SHOFFNER CONSULTING

April 3, 2017

Revision #3: May 10, 2018

RE: Tree Inventory - 8253 West Mercer Way, Mercer Island, WA. 98040

SHEET:
C3.2

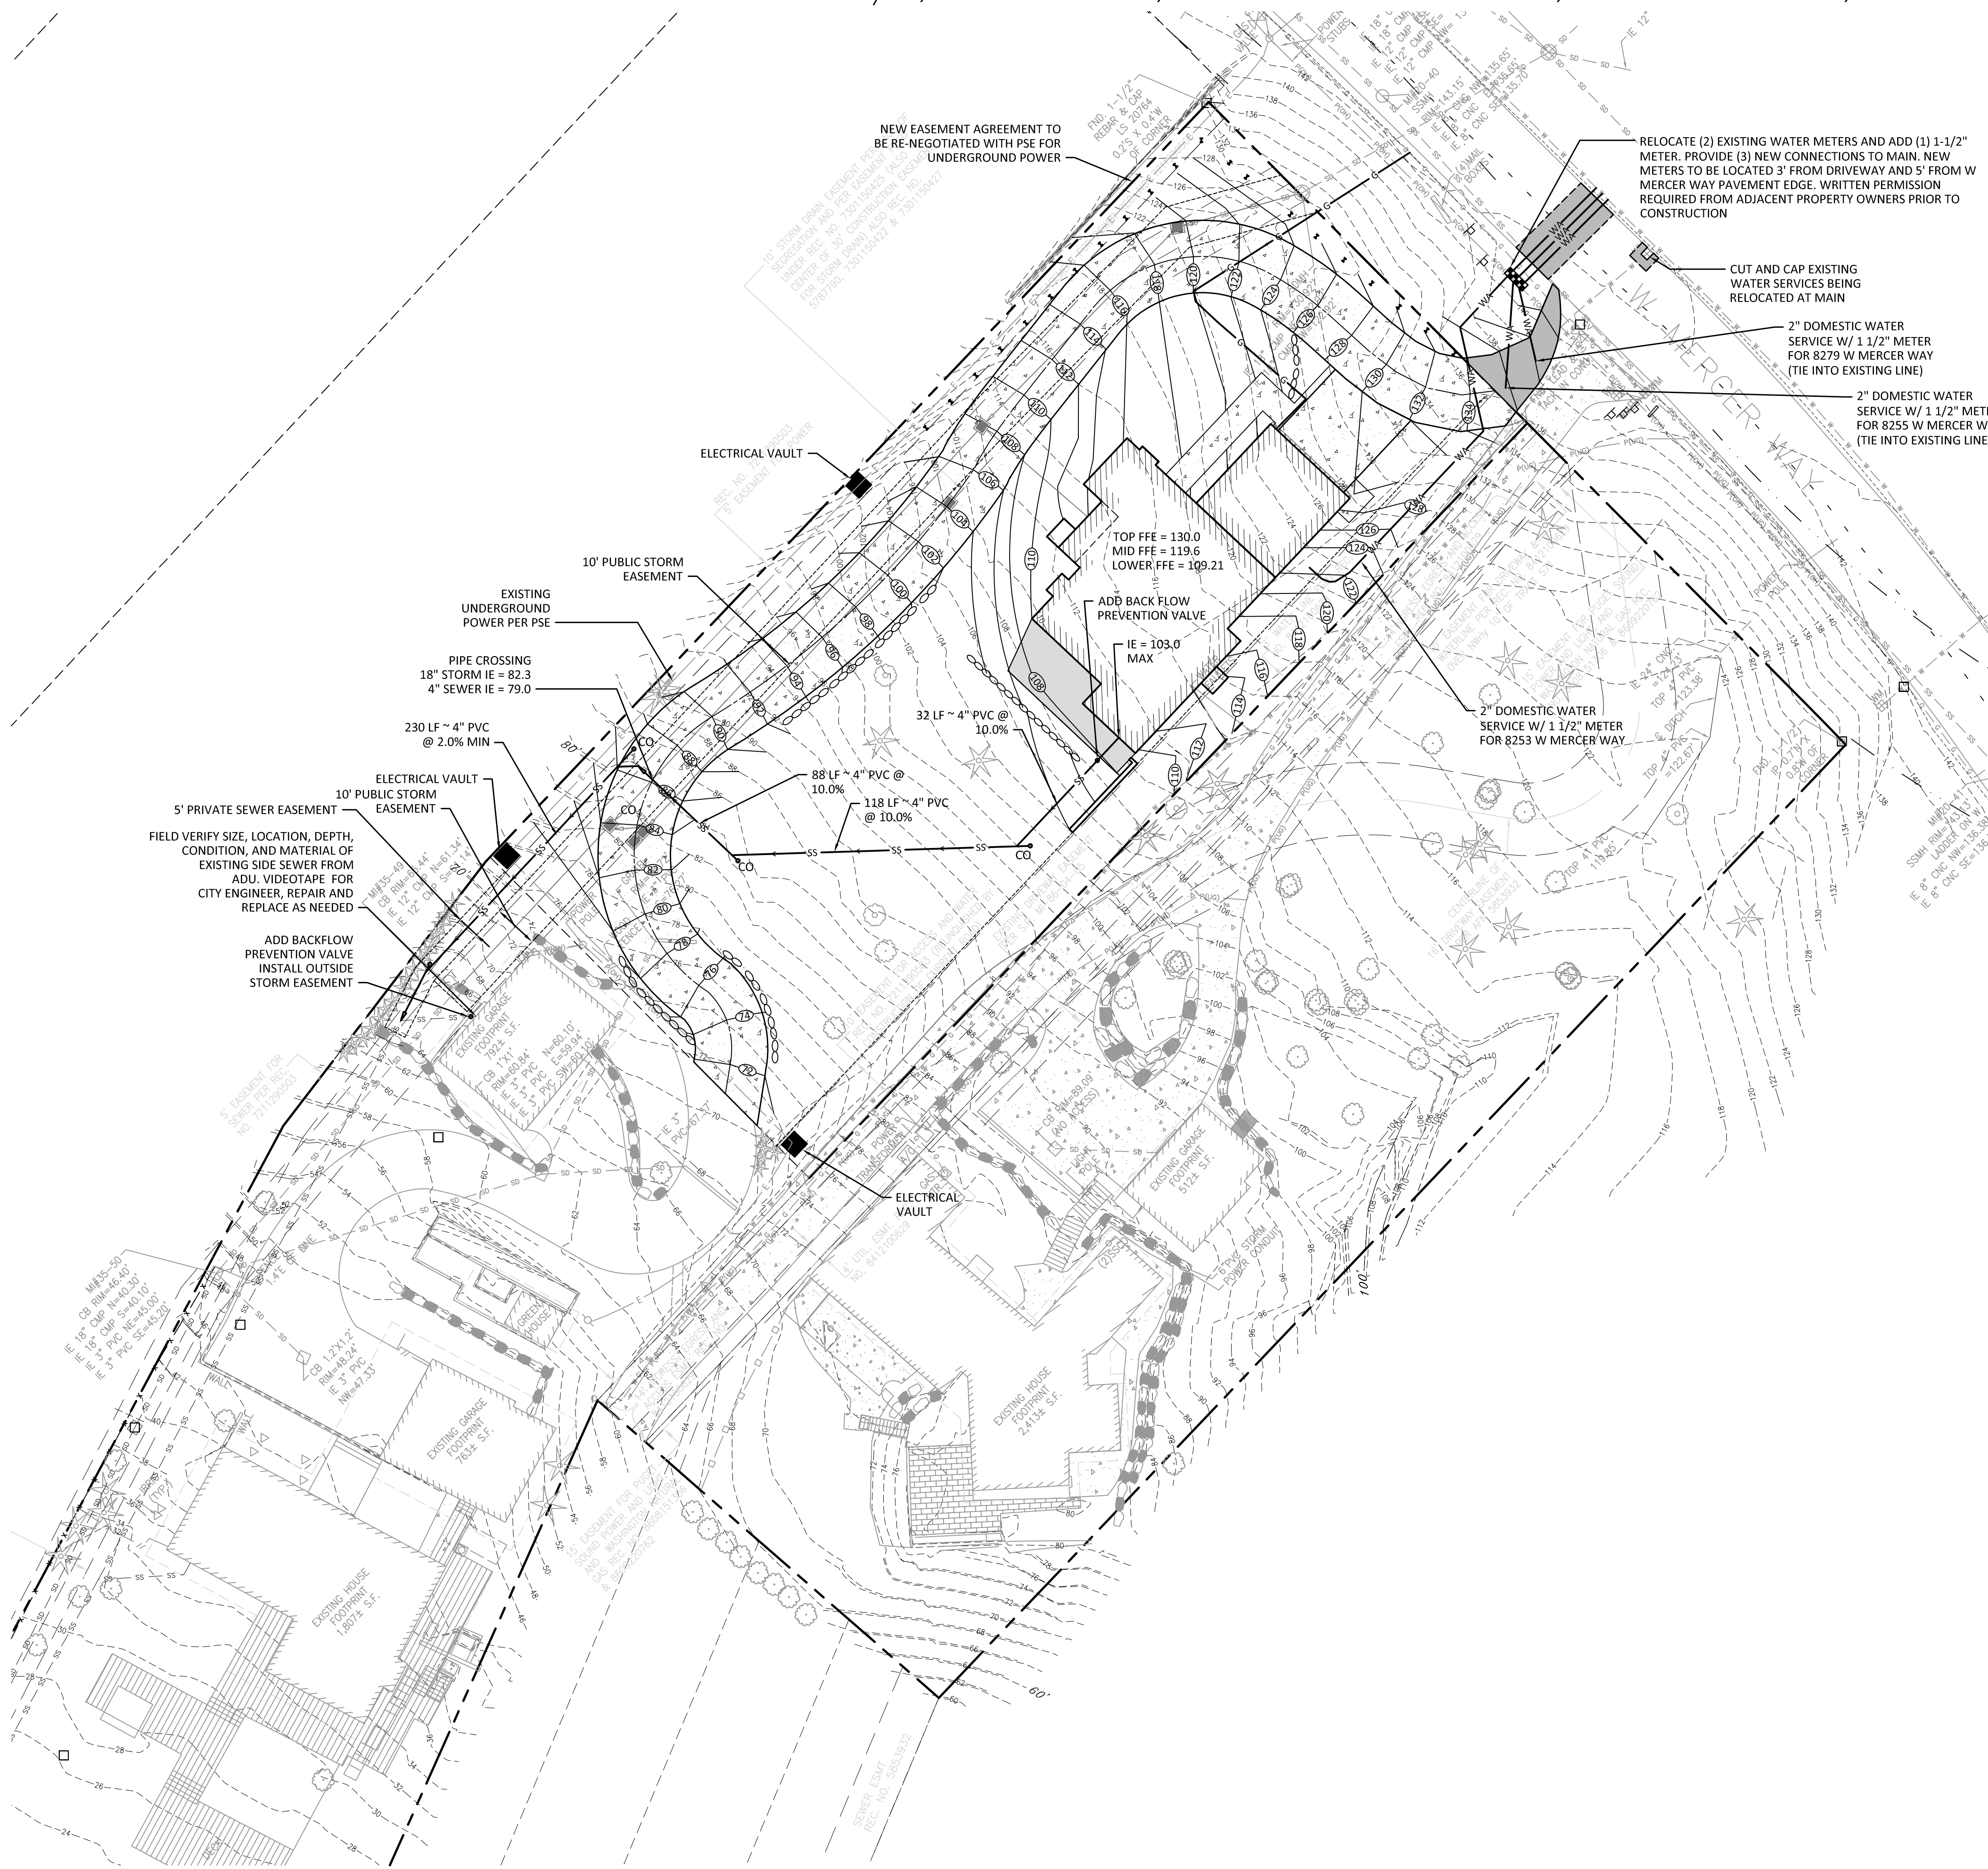
- Tree numbers on plans for easy identification of individual trees to be saved and/or removed.

- Show driplines of regulated trees to scale.

- Show protection plan for work proposed within dripline of protected (retained) tree (#43).

- Attempt to use best building practices to retain trees 20 and 22 (grading and retaining walls are in conflict).

- Tree next to tree #1 not numbered.

- Confirm all significant trees even if not on survey are included on plans.

- Show tree protection for tree 44.
- As stated in my intake comments use best building practices to retain trees 20 and 22. Remove new grading from within saved trees dripline.
- Show tree protection for trees 16-18.

- All tree numbers were shown on the Tree Retention Plan at the last submittal and are currently shown on the revised plan.

- All driplines of regulated trees, both to be retained and to be removed, are provided on the Tree Retention Plan.

- The Tree Retention Plan shows the location of the tree protection fencing at the dripline of the retained trees. No impacts are allowed within the tree protection area and no impacts are proposed.

- Retaining walls and extensive fill upwards of 10 feet deep are proposed in around trees #20 and #22 for the creation of a level front yard. Installation of the retaining walls will require excavation through the root zone of tree #20 resulting in considerable root damage and loss. Placement of 10 feet of fill over the root zones will greatly diminish the availability of air and water for these trees affecting their health. There are no building practices that will allow for the retention of these trees.

- The tree next to #1 has been numbered on the Tree Retention Plan and information on this tree has been provided in the Tree Evaluation Data spreadsheet.

- All significant trees on the new lot that were identified during my initial inventory and evaluation for the original submittal of this report and plan are shown on the Tree Retention Plan.

- Protection fencing is shown for trees 16, 17, 18 and 44 on the updated plan.
- As informed by the project engineer, the proposed development will not allow for retention of trees 20 and 22.

Tree #22 is now being retained and is shown without impacts within its dripline.
